Planning Application Ref: **WA/79/20/PL**

Location: **Spindlewood, Yapton Lane, Walberton, BN18 0AS**

Description of works: **Demolition of existing dwelling & erections of 8no. new dwelling houses with associated landscaping & parking (resubmission following WA/30/20/PL). This application is a Departure from the Development Plan & is in CIL Zone 3 and is CIL Liable**

Mark Warwick
Tree Officer / Parks and Greenspace Team

TREE PROTECTION PLAN

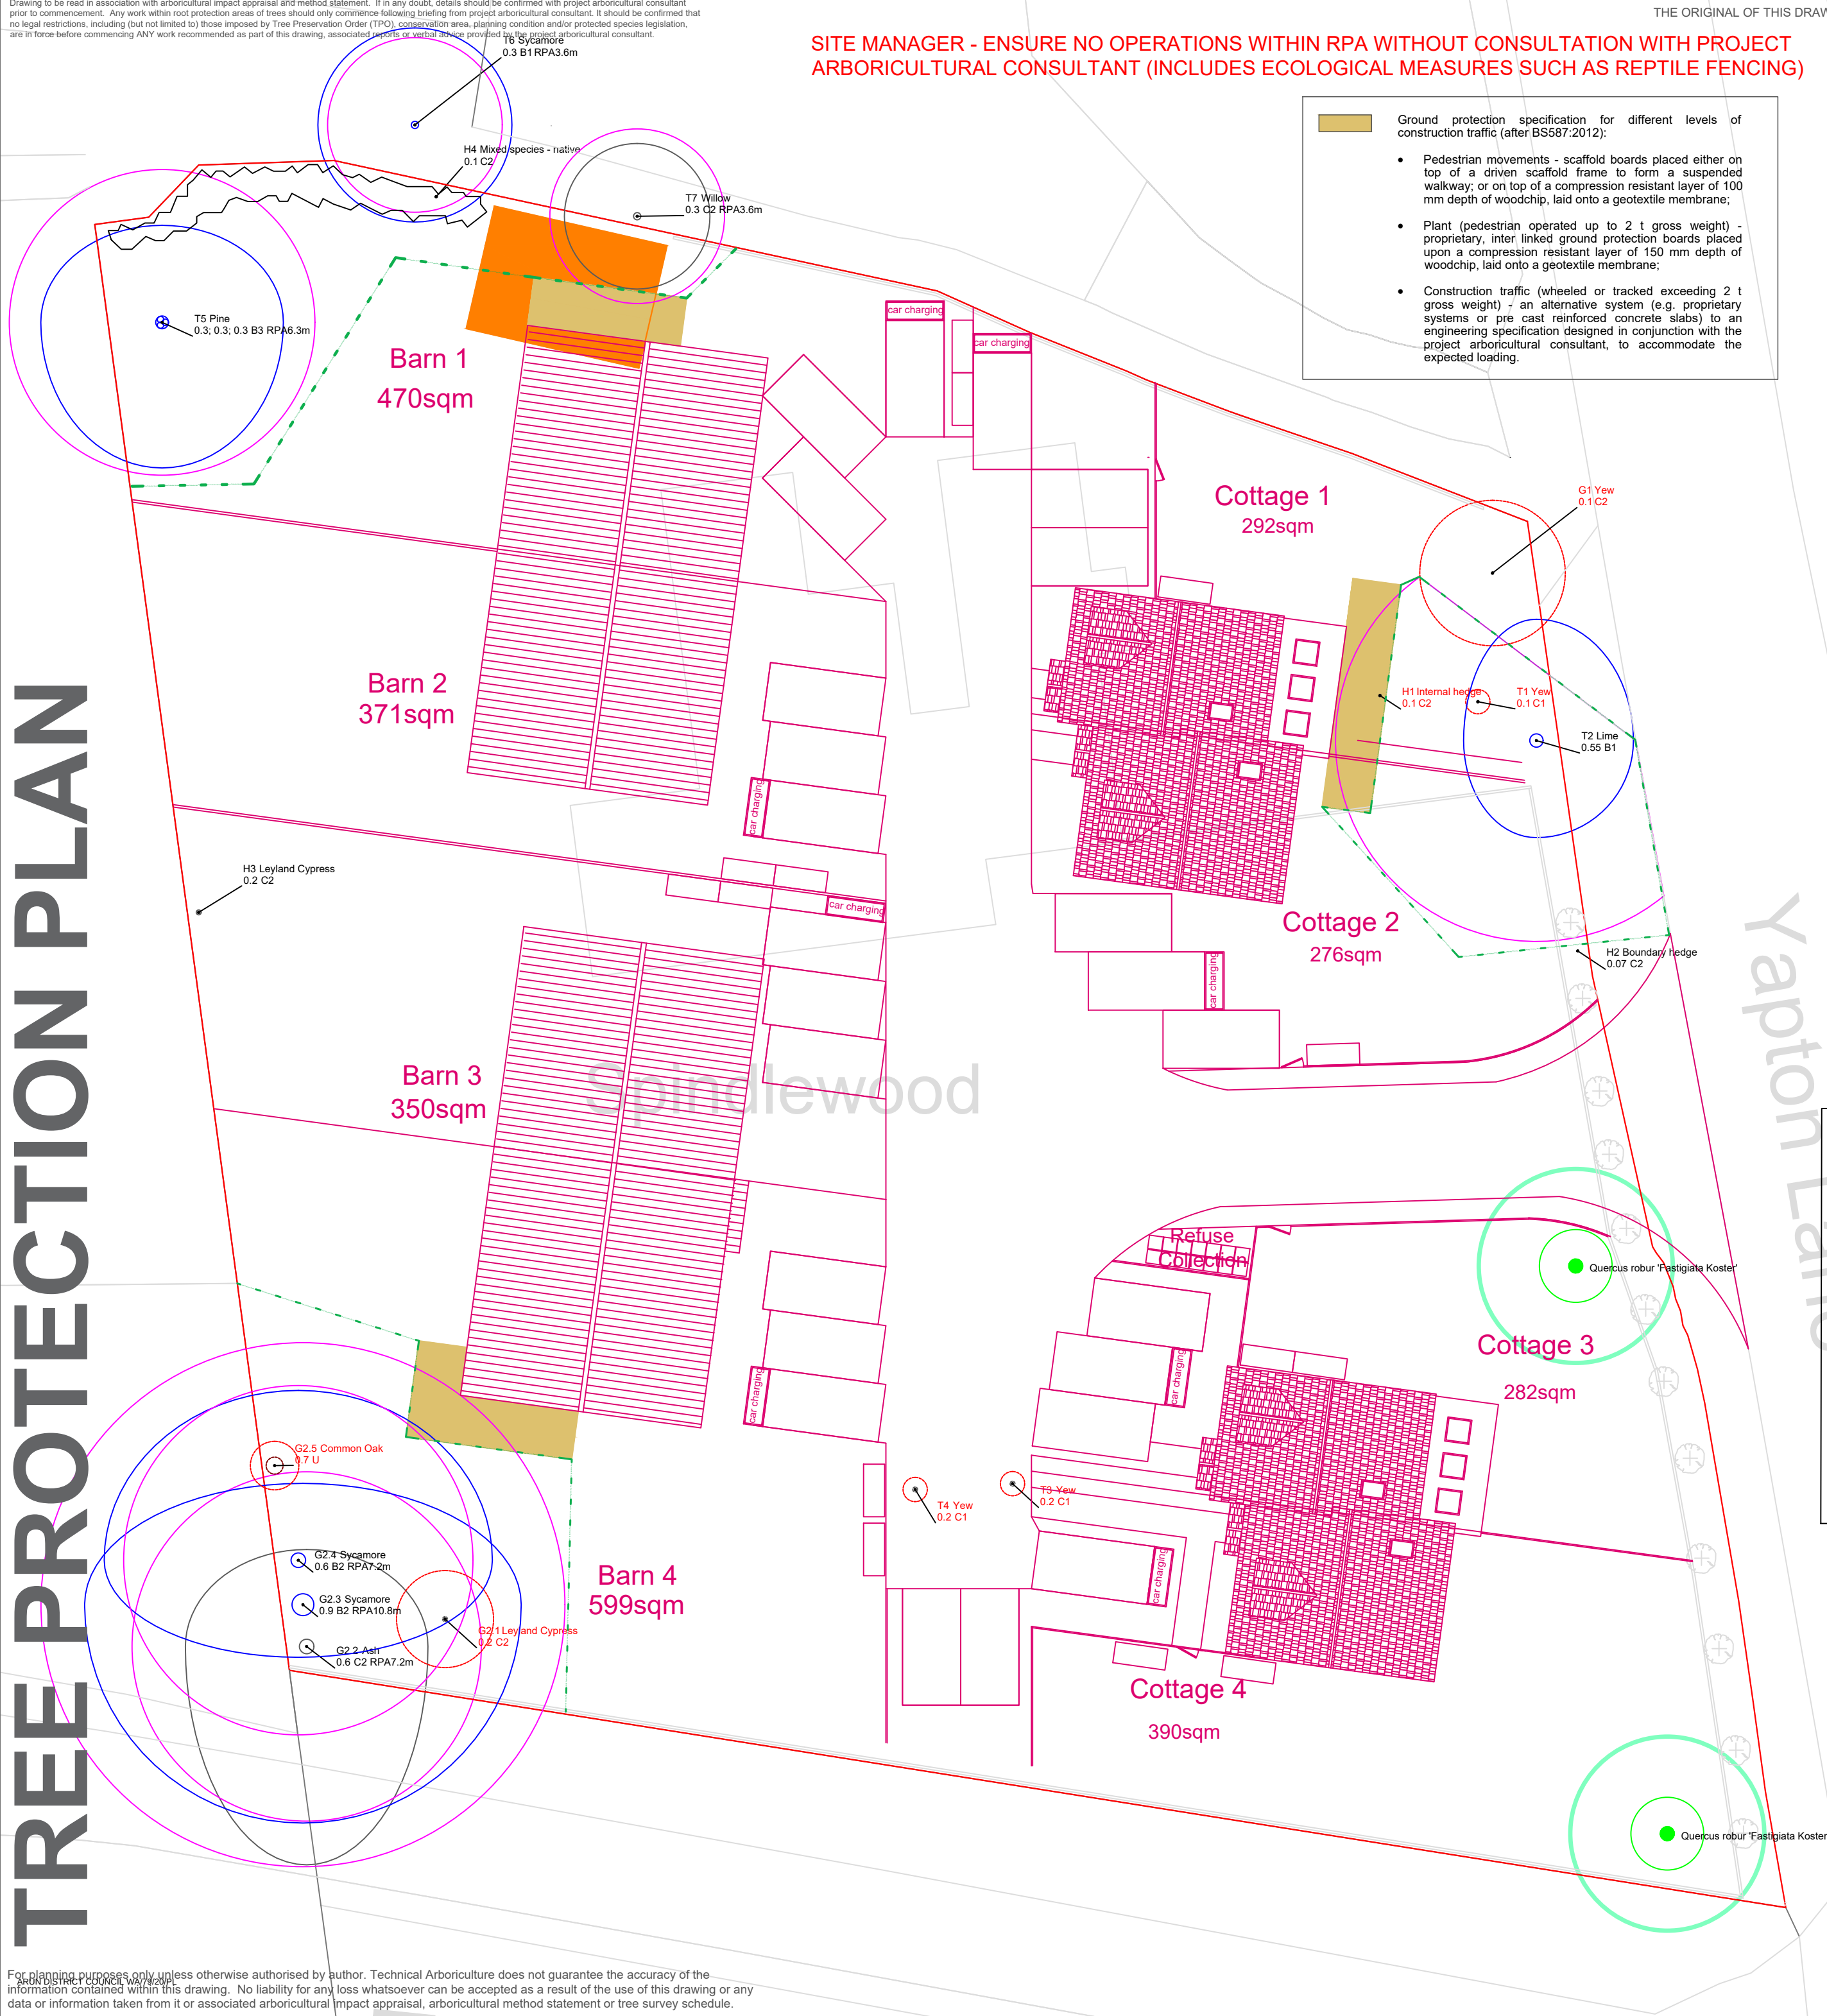
- I am pleased to note within the AIA&MS (and illustrated on the Tree Protection Plan) a proposal to plant two semi-mature fastigate oak trees in prominent locations. Those will associate well with surrounding landscape and can ultimately compensate for planned tree removals across the site.

- I recommend the above scheme for **APPROVAL**, subject to the following conditions being applied:
1. Before the site is occupied or any machinery is introduced to the site or demolition work or construction work or alterations to existing ground levels takes place a **PRE-COMMENCEMENT Site Meeting** is to take place between the Planning Authority's Tree Officer and the Arboricultural Expert representing the site owner(s) – at this meeting all protective fencing and ground protection measures will be inspected to verify they are 'Fit for Purpose' as required under British Standard 5837:2012 and have been erected and positioned exactly as shown on the **Tree Protection Plan, dwg. no. TPP-KC/SPINDELWOOD/001, July 2020.**
